ADJACENT LANDOWNER SUBMISSION OF COMMENTS
REGARDING PROJECT FILE NUMBER EGP241, OVERLOOK AT HOMESTEAD EARLY GRADING
SUBMITTED BY:
ROGER AND JOANN LUND, TRUSTEES OF THE LUND FAMILY REVOCABLE LIVING TRUST,
OWNERS OF APEX RANCH ESTATES LOTS 15 AND 16; AND
KEITH AND CHERYL KIM, MEMBERS/PRINCIPALS OF TRES BOYS LLC,
OWNERS OF APEX RANCH ESTATES LOTS 17 AND 21
SUBMITTED JULY 22, 2024

OVERLOOK FILING NO. 1  
EL PASO COUNTY, COLORADO  
PRELIMINARY DESIGN PLANS  
PROPOSED DRAINAGE MAP

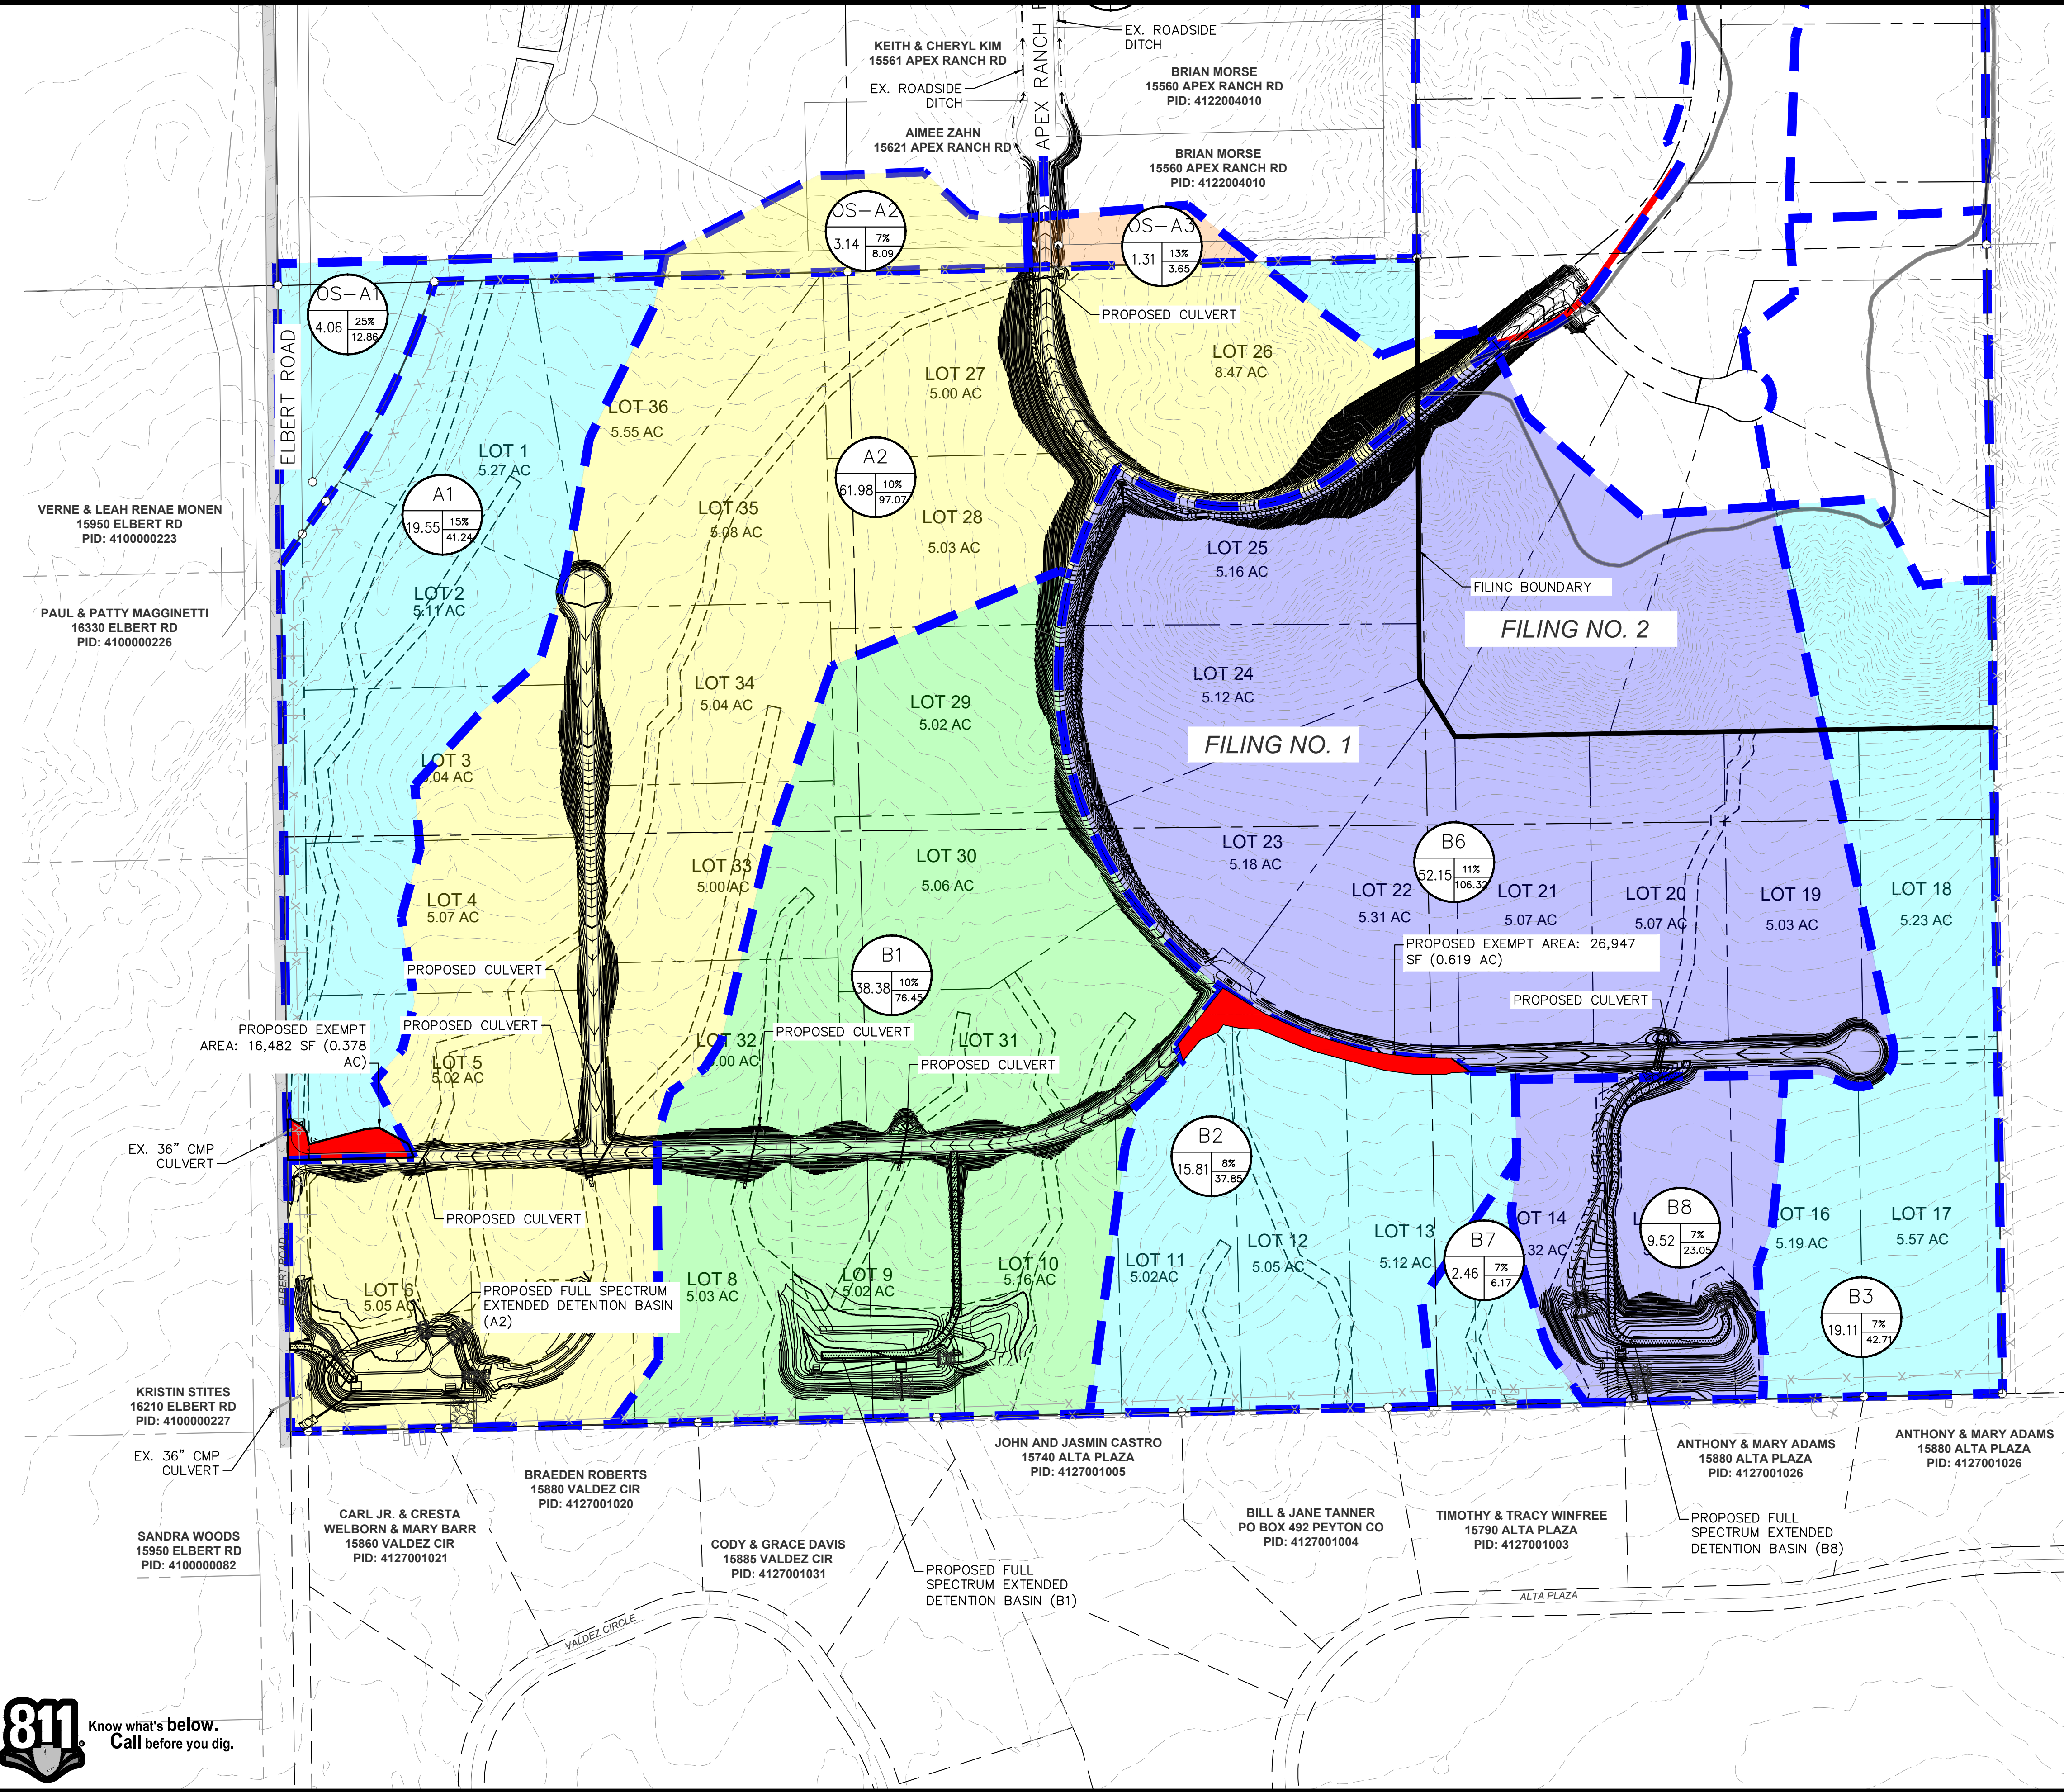
Specifically, it is our assessment that the proposed location of the detention pond identified as C6 on the Kimley-Horn proposed drainage map sheet EX-2, which straddles Lots 58 and 59 of the Development, will be insufficient to mitigate the historic flows we have witnessed during our residency of our properties. The source of these flows originates in the two large drainages across these Lots and converge into a single even deeper and wider drainage which flows between Lots 16 and 17 of Apex Ranch Estates.

I accessed the EDARP site recently and saw that Early Grading Plan #EGP241 and related documents were presented on May 7, 2024. In the Final Drainage Report and Stormwater Management Plan included therein, the location of the detention pond in question has not changed from the Preliminary Plan. Apparently those involved believe that our concerns previously voiced are of no merit. Having watched the drainage in question run bank-full during heavy rains, and knowing that development above us will create impervious surfaces which can only increase flows from the Development onto our properties, we are again making our concerns known before the project is finalized and approved.

We accept the fact that the Overlook Development will occur, and ask that sufficient stormwater drainage design and implementation is provided to protect from damage to our properties, whether that be moving the detention pond downstream below the confluence of the two drainages, or construction of another detention pond on the other contributory drainage. Again, the pond in question is the only one of six proposed detention ponds which do not capture flows immediately before leaving Overlook property to protect adjacent downstream properties owned by others. It is the responsibility of the Developer to ensure effectiveness of location and design of any detention pond in mitigating downstream flows over how easy or cheap it would be to build it, or how many trees must be moved, or how easy it is to access.
